Action Point	Response
6	Confirmation that Northumberland County Council (NCC) are satisfied with text in Art 7(b)(ix).	From a highways perspective, we are satisfied with the text as set out in Art 7(b)(ix)
7	NCC to respond to the Applicant's response to ExQ1 DCO.1.39 and DCO.1.40, in relation to Art 11.	The applicant's response to ExQ1 DCO.1.39 confirms that the revised DCO has consistency in notifying the Street Authority at 6 weeks and, as such, have no comments to make. (Noting DCO.1.40 is linked more to Article 12 so comments have been made on this under Point 8)
8	Applicant and NCC to consider Art 12 and identify any matters of disagreement.	Following on from our meeting with the applicant on 15th February, the applicant's consultant has shared notes of the meeting on 10th March, which have provided clarity in relation to Article 12, along with the points of clarity made in the Hearing Sessions. It is understood that these notes will form subsequent iterations of the Statements of Common Ground to which we will comment and confirm.

Response to Point 36

Figure 36.1 Extract from TADU ATC Traffic Speeds Dashboard (Source: TADU 2018)

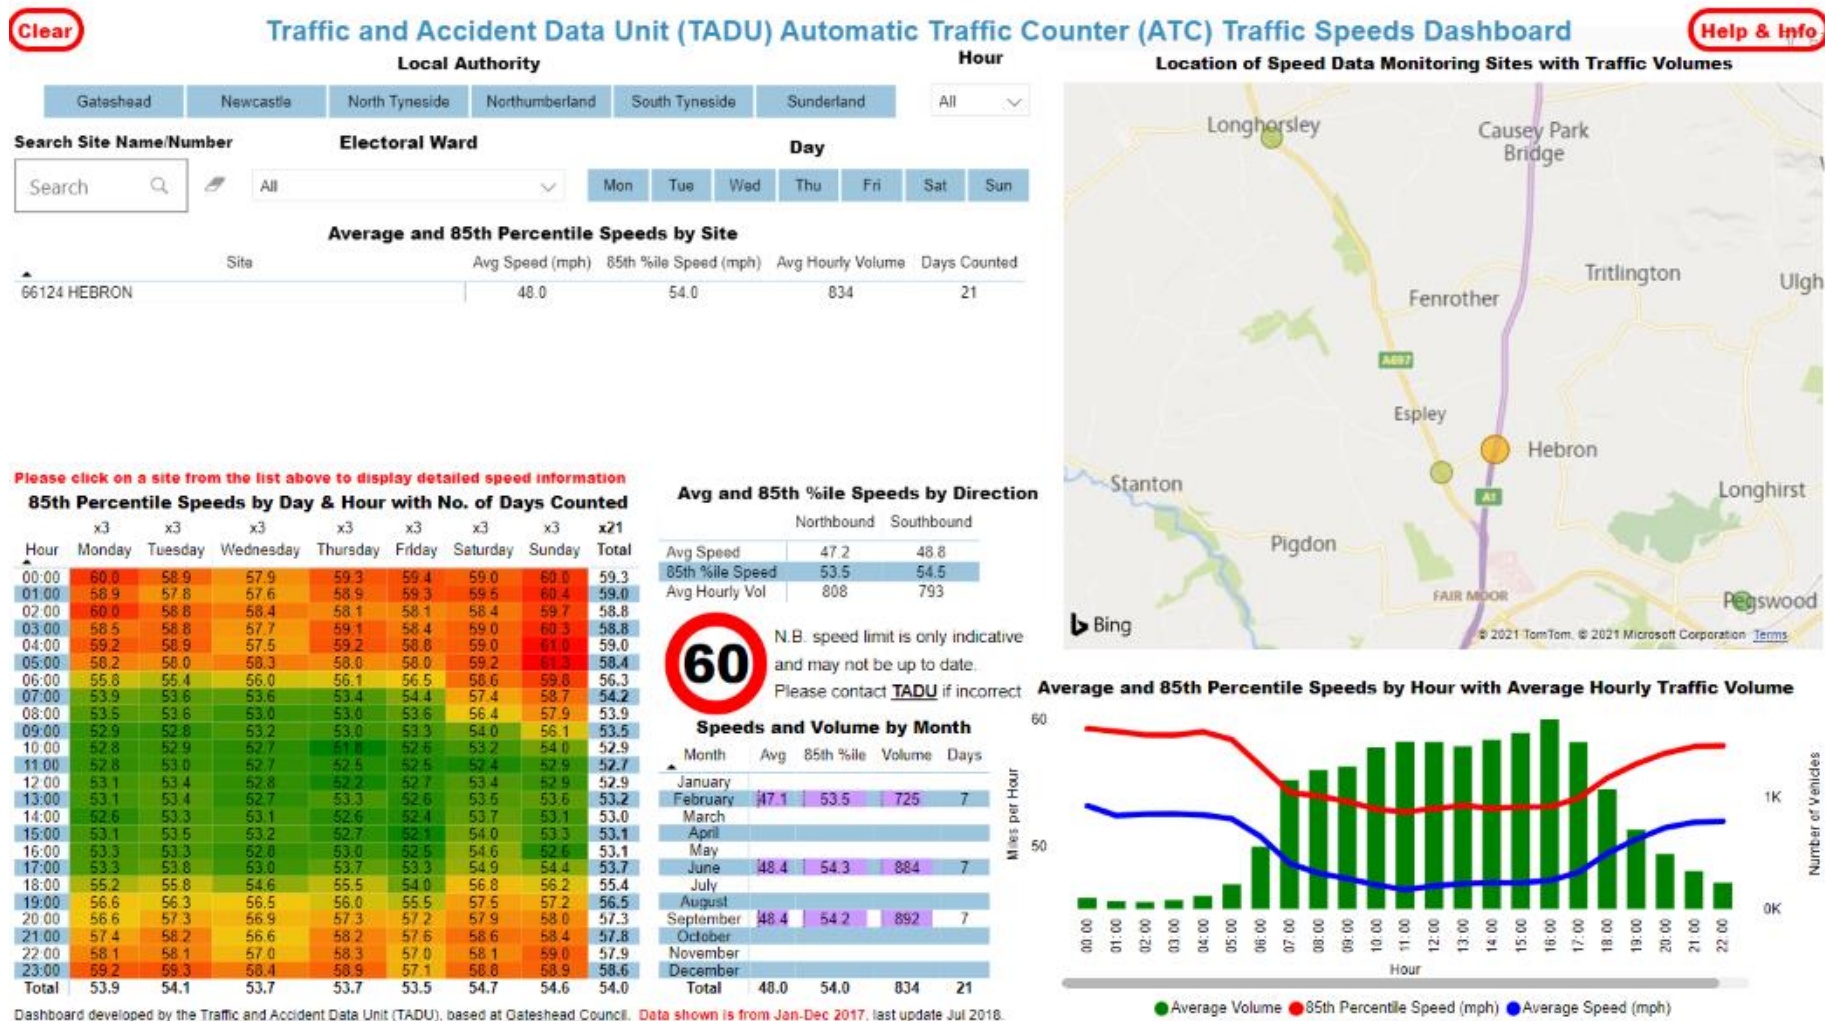
Analysis of these flows indicate an 83% reduction on the 2020 figures and 87% reduction on the 2019 figures on the busiest section (Fenrother to Earsdon). The reduction in traffic flows will lead to an increase in traffic speeds. Figure 36.1 below shows the 2017 traffic speeds at Hebron on the A1. Although showing hourly figures for volume of traffic, the graph (bottom right) shows how speed increases as traffic flows drop. Based on this we would predict at least a 5mph increase in the 85th percentile speed on the de-trunked section as a result of the reduction in traffic flows.

The current WS2 standard road width combined with a good horizontal and vertical alignment and good forward visibility will also contribute to potential further increases in traffic speeds.
